TfNSW Reference: SYD20/00117/04

DPIE Reference: SSD 10425

**RESPONSE TO SUBMISSIONS STAGE 2 DETAILED DESIGN - TALLAWONG STATION PRECINCT SOUTH, 1-15 & 2-22 CONFERTA AVENUE, ROUSE HILL**

TfNSW has reviewed the response to submissions and provides the following comments:

CONFERTA AVENUE SITE SECTION S

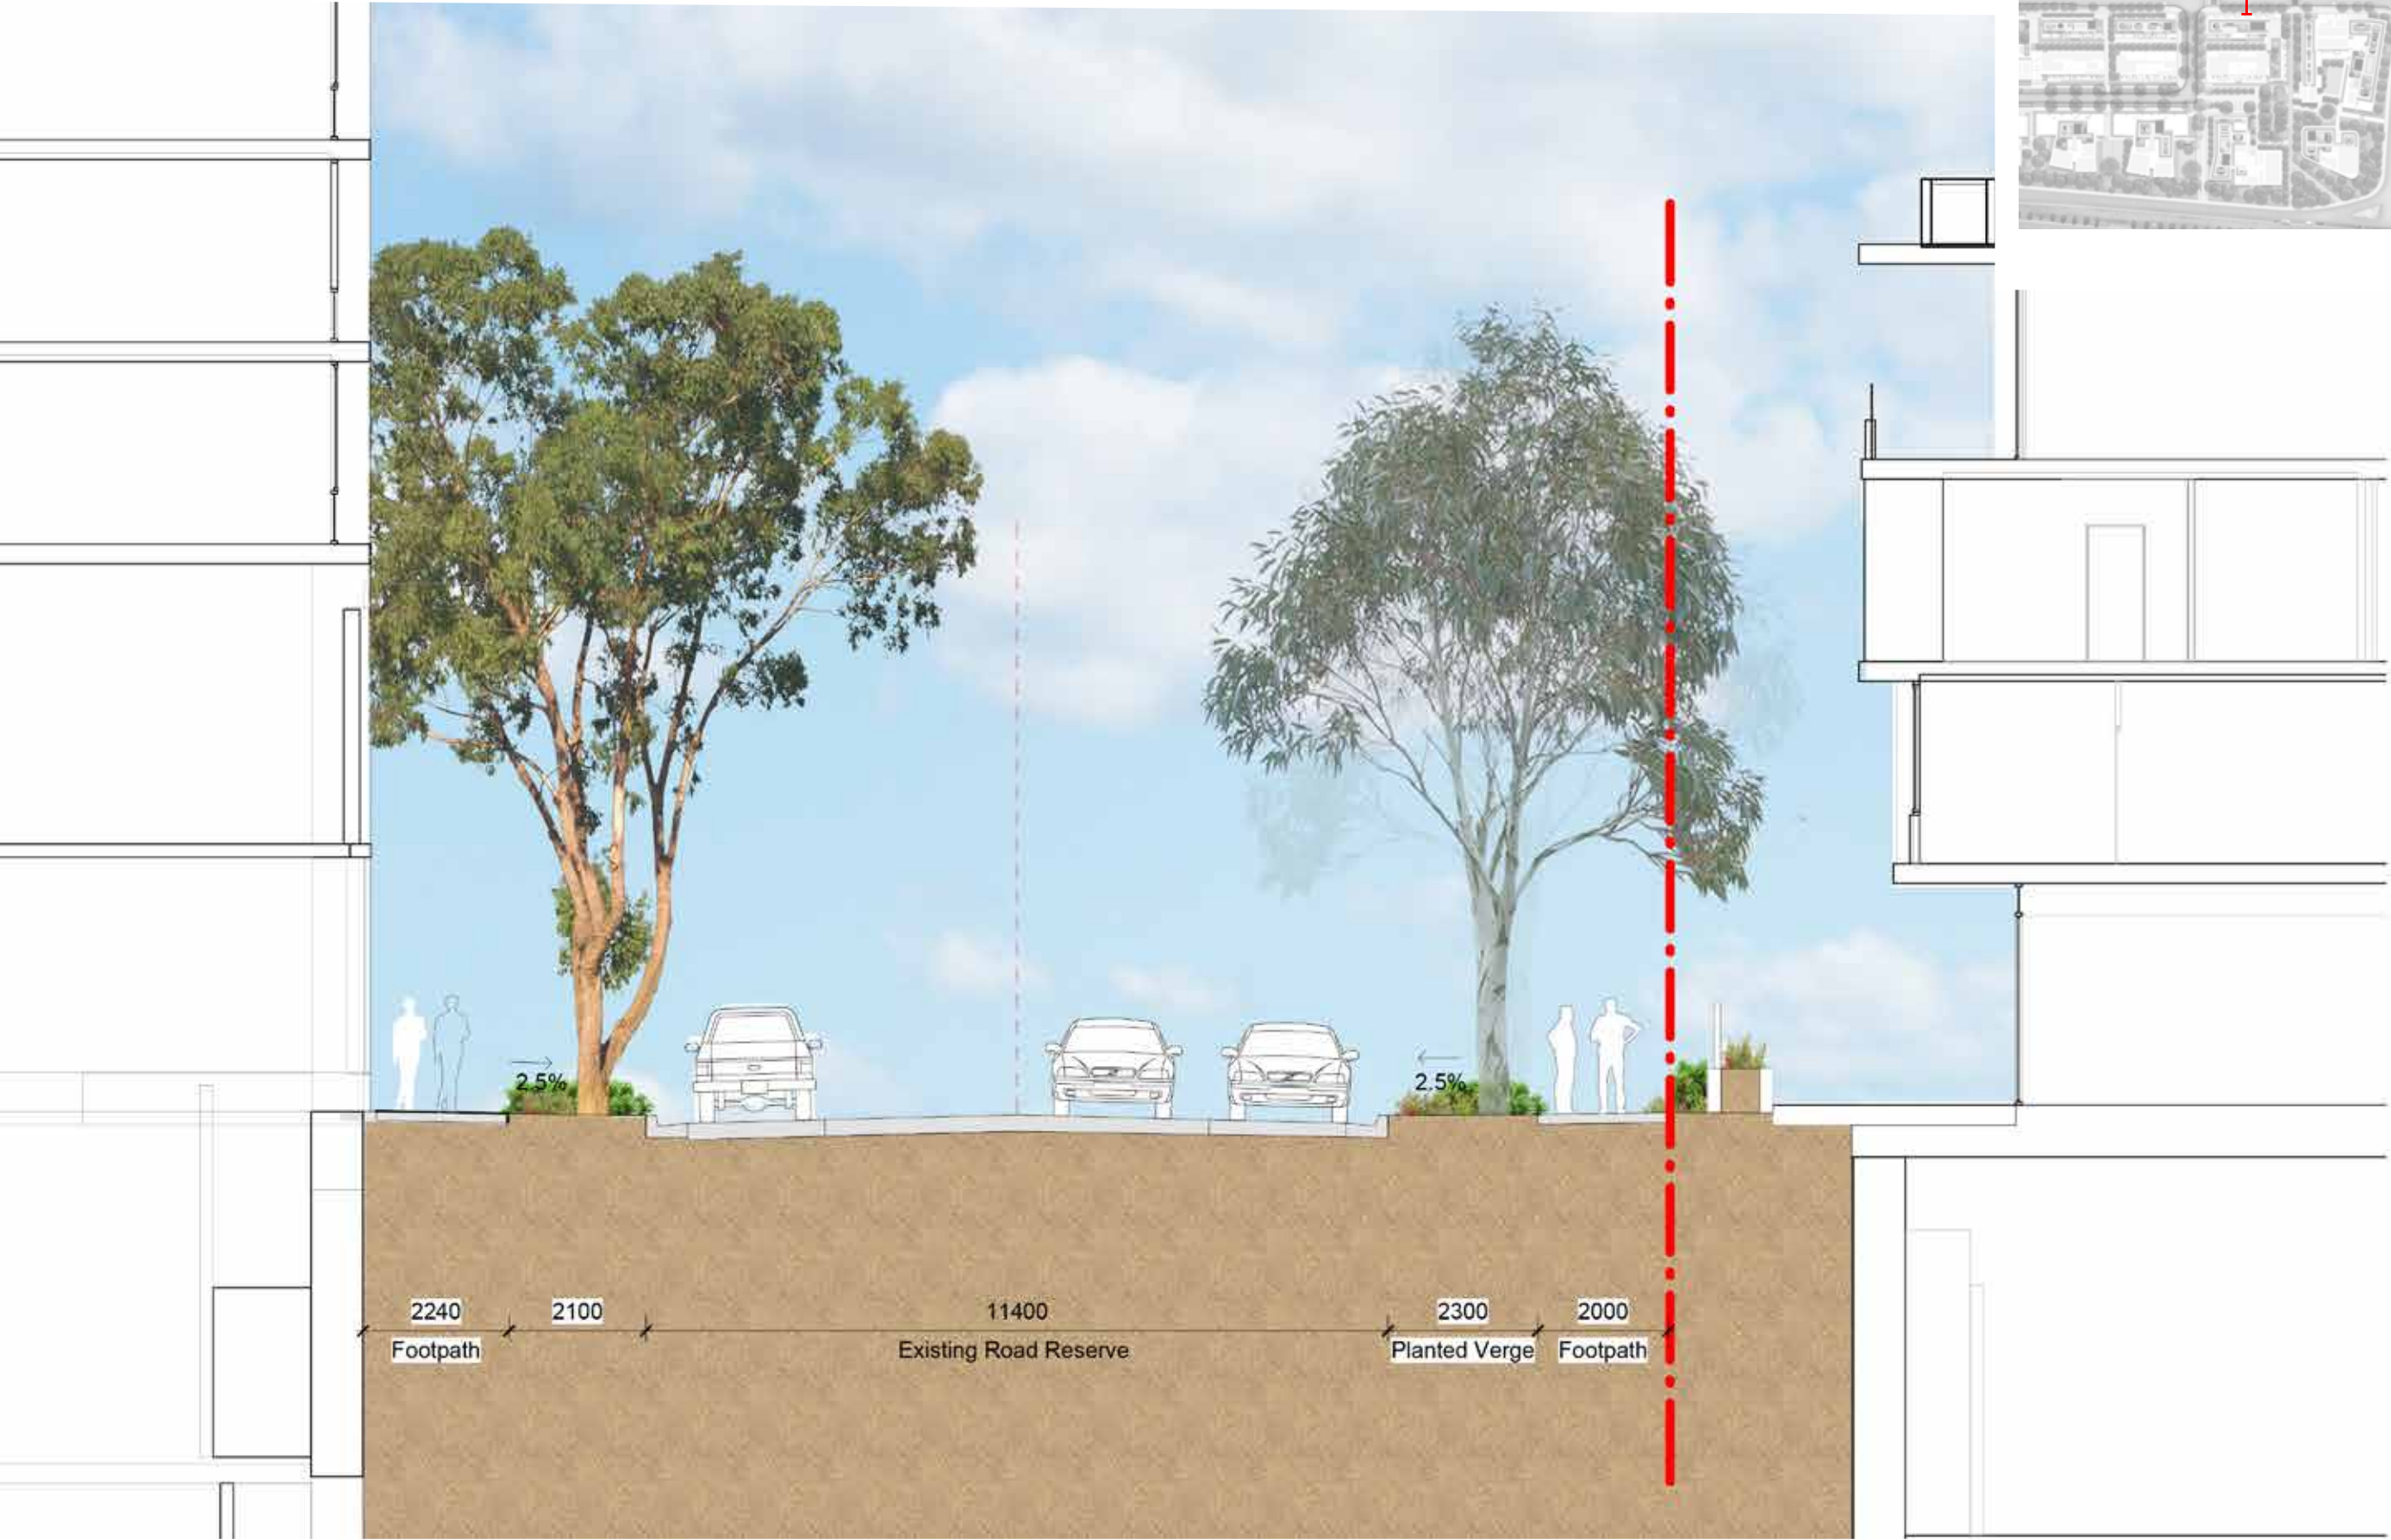
TfNSW policies of integrating transport with land use emphasises the importance of walking and cycling for short trips and reinforces the importance of walking and cycling to increase the catchment of public transport as part of the whole customer journey. To assist in delivering a comprehensive active transport network, TfNSW recommended:

- The northern footpath on Conferta Avenue for the length of the development site frontage be designated as a shared path with a minimum width of 2.5m (wider if possible); and
- The southern footpath on Conferta Avenue for the length of the development site frontage be widened to 2.5m (wider if possible) and designated as a shared path.

The response provided in the RtS “Footpaths are consistently provided on both sides of the roads in the Development”, does not adequately address TfNSW comments or recommendations.

In order to progress TfNSW policies of integrating land use with transport, and deliver a comprehensive active transport network, it is recommended the above improvements to active transport infrastructure on Conferta Avenue are conditioned as part of the development approval.
